Permit Number: 051237

CITY OF PORTLANDThis is to certify that ONE CITY CENTER ASSOCIATES L.P. ishas permission to Add railing to existing deckAT 1 CITY CTR

City of Portland, Maine - Building or Use Permit Application

Proposed Use: Commercial/ add railing to existing deck-on existing 3rd floor patio	Proposed Project Description: Add railing to existing deck
--	--

RAILING CROSS-SECTION

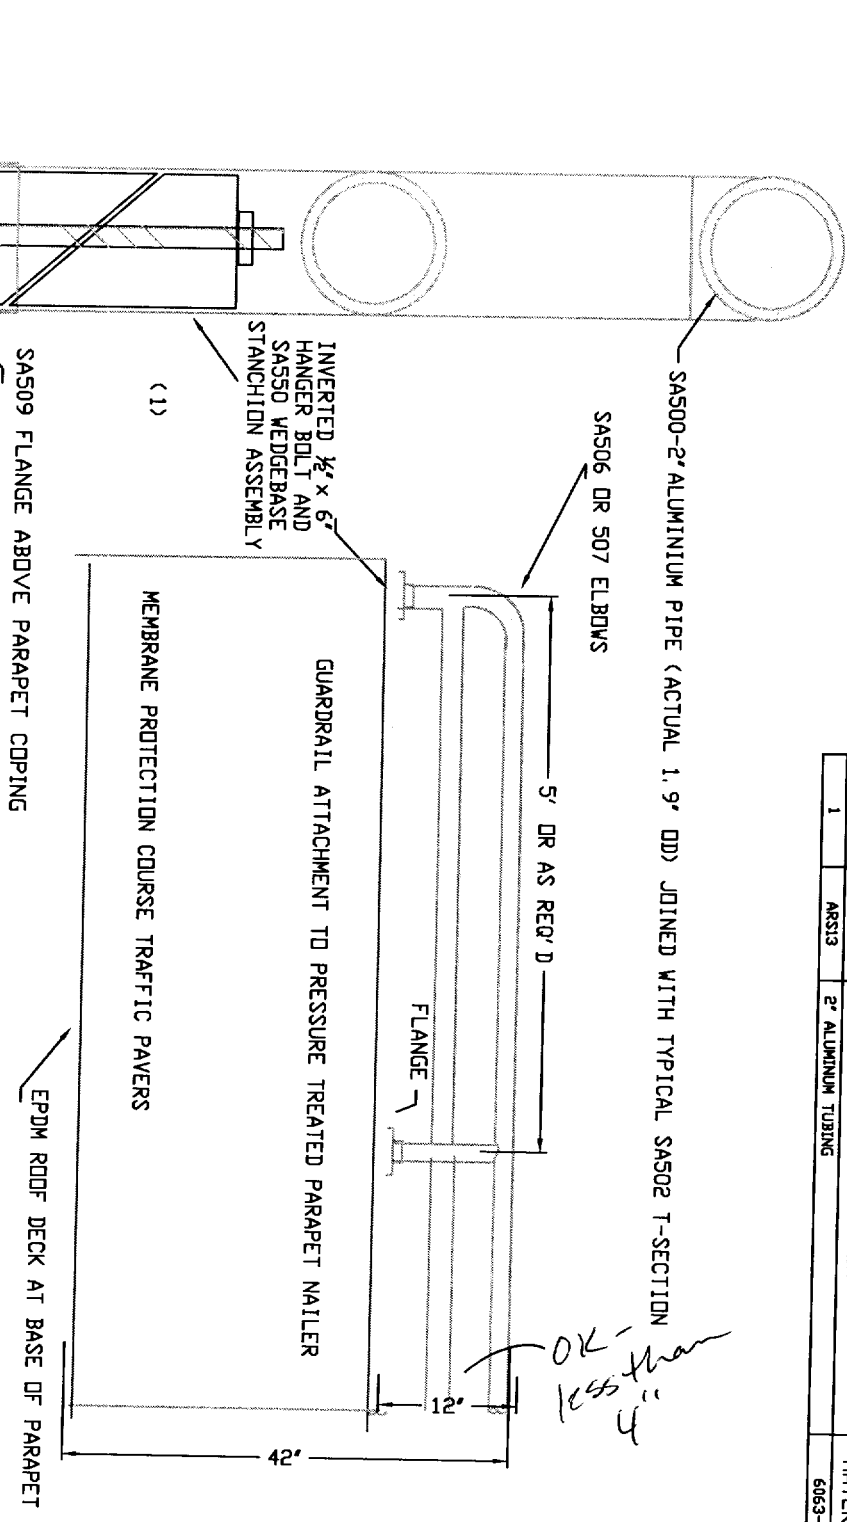
OK - less than 4"
